Acoustic Expert Report
Of
Ian MacArthur
Clarke Saunders Associates

THE PLANNING ACT 2008 PINS Ref: EN010168
Application by Lime Down Solar Park Limited for an Order granting
Development Consent for the 'Lime Down Solar Project'

SLD Wiltshire Limited

APFP Regulation: 5(2)(a)
Application Doc No.: APP/6.2
Drawing no.: 14-3

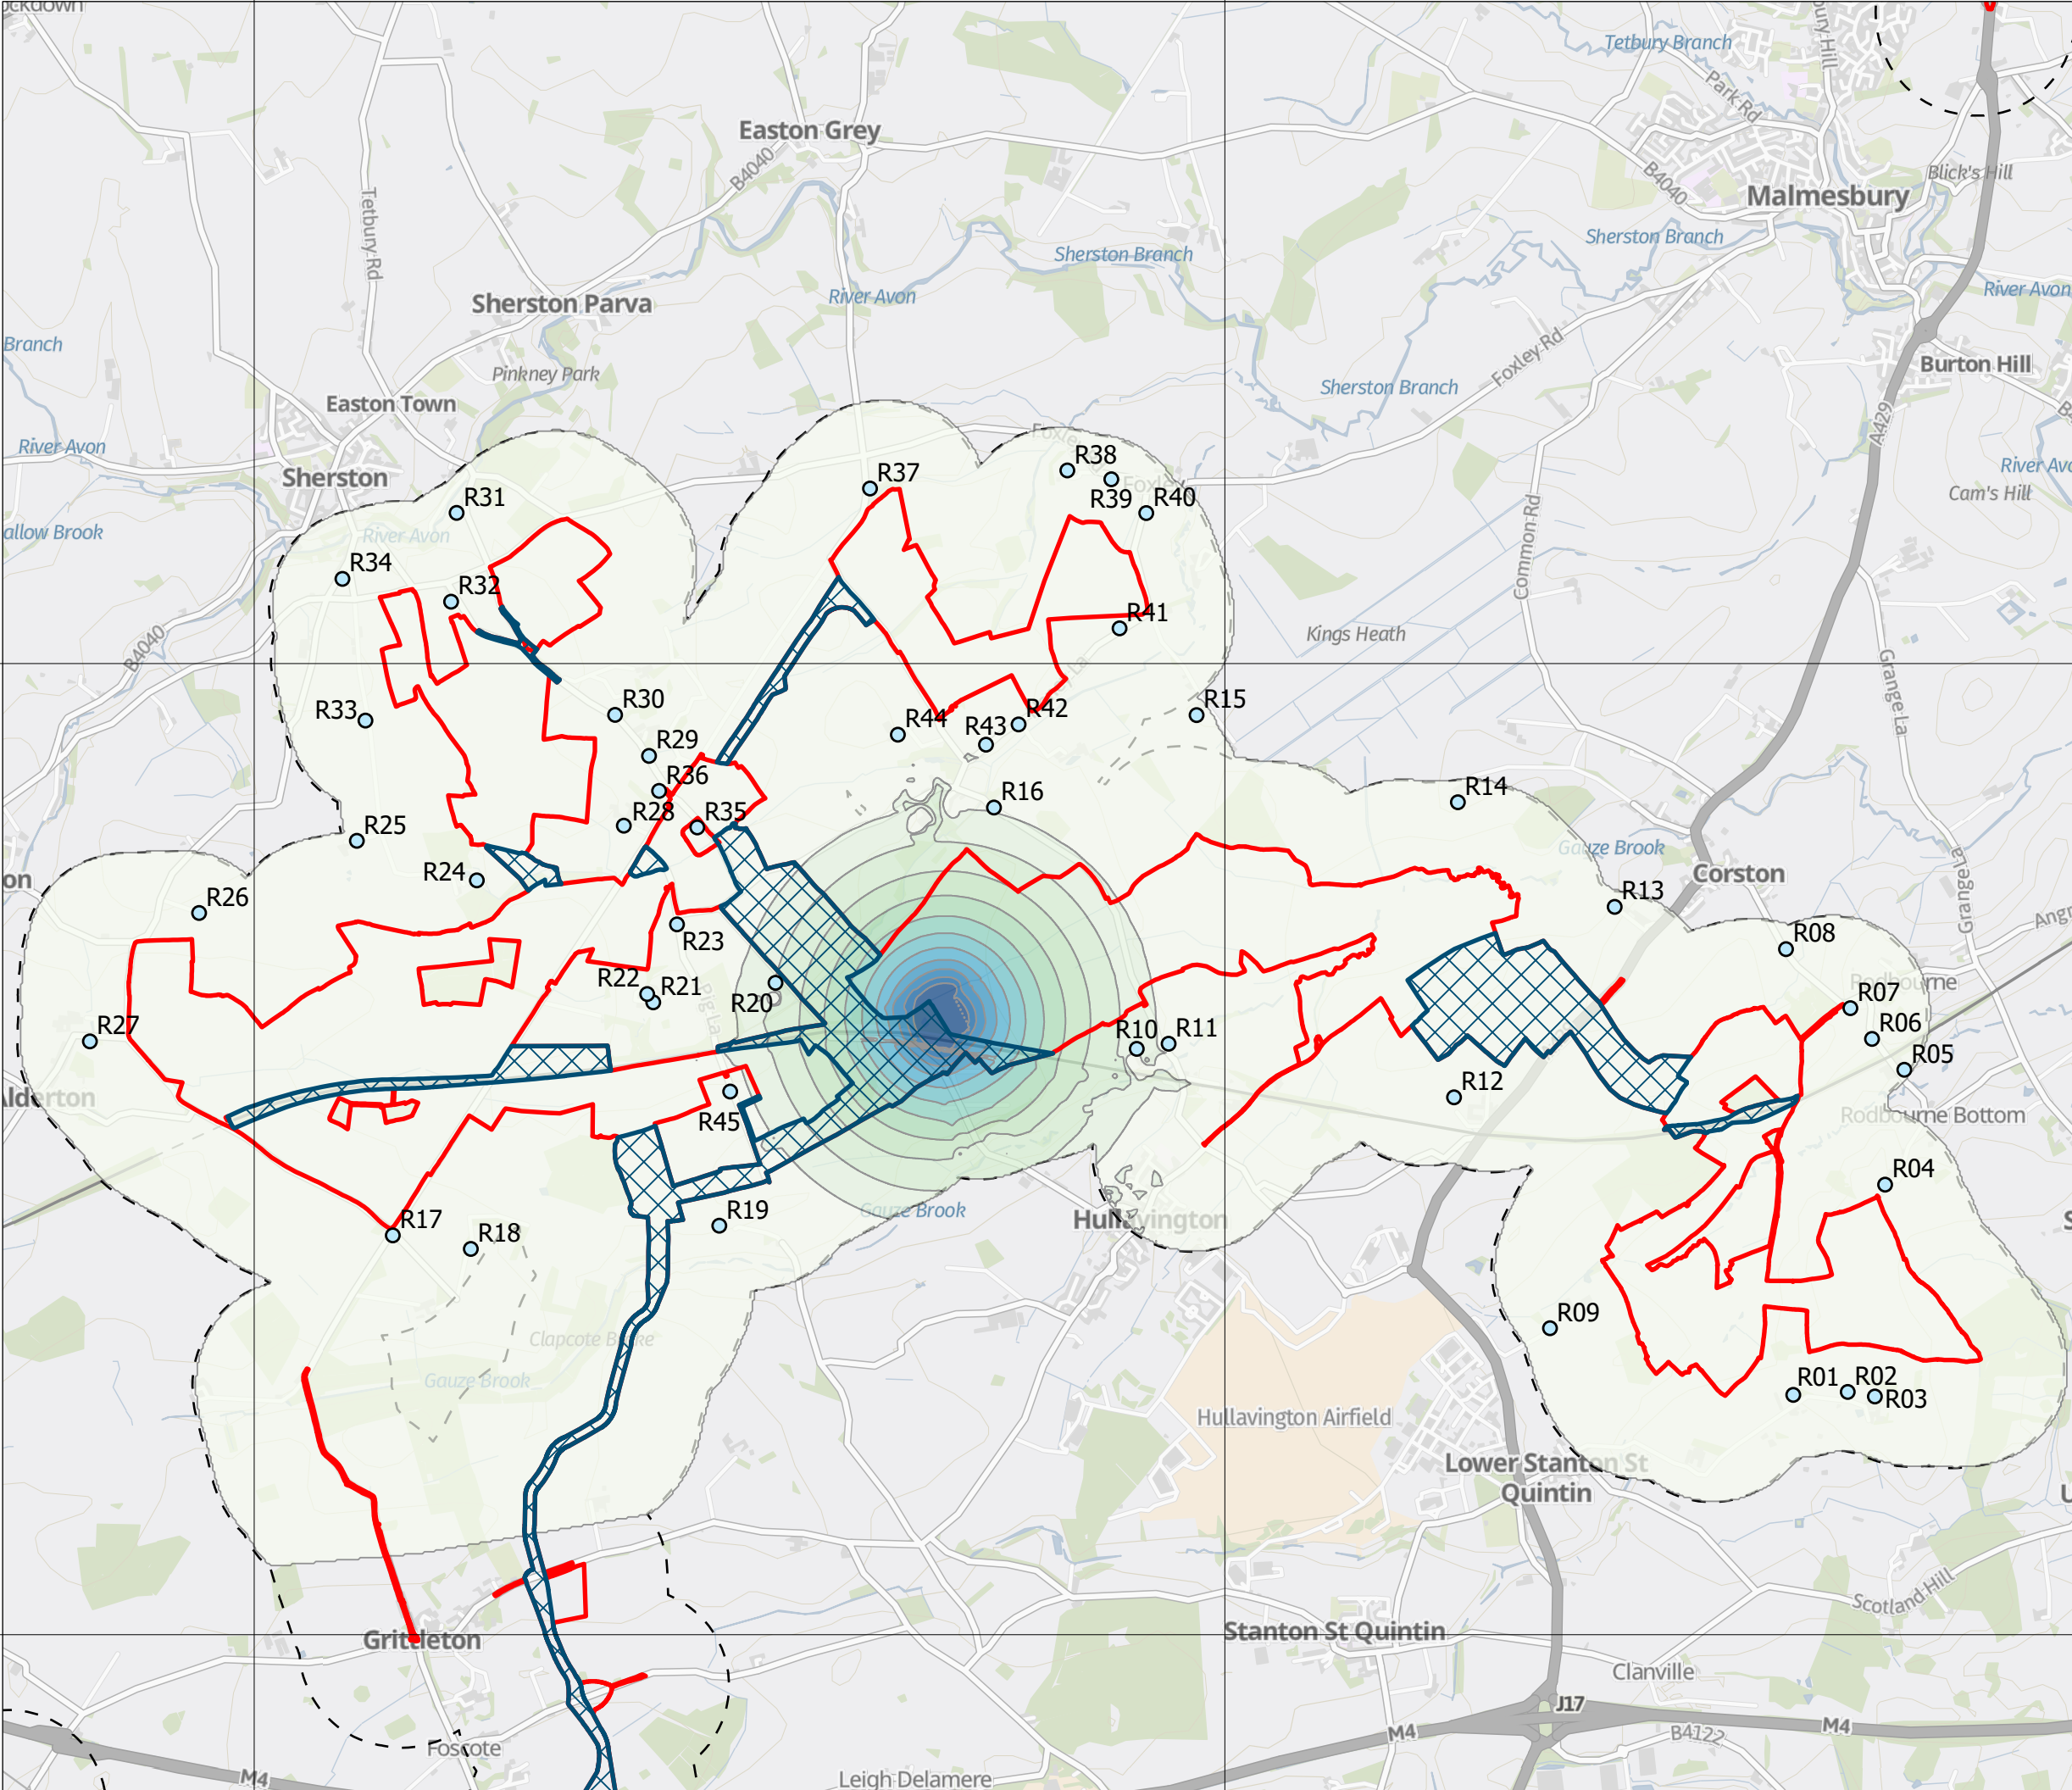
- 5.17 In contrast, the appropriate background noise level values from this dataset I have suggested above are further justified by the exclusion of the outlier data from 28 October 2023. Were 30dB _{LA90} during the daytime and 25dB _{LA90} at night to be applied to the Applicant’s assessment of prospective noise effects (respectively, Tables 8 and 9 of the Applicant’s Noise Modelling), the exceedance would be 7dB in the daytime (a predicted rating level of 37dB_{LA_r, Tr}) and 10dB in the nighttime (a predicted rating level of 35dB_{LA_r, Tr}). For R20 this would result in SOAEL effects in both the daytime and night-time, and for this sensitive residential/agricultural receptor (applying the Applicant’s own matrixes), a major/moderate effect in EIA terms in the daytime (2dB exceedance of the SOAEL) and a major effect in EIA terms in the night-time (5 dB exceedance of the SOAEL).
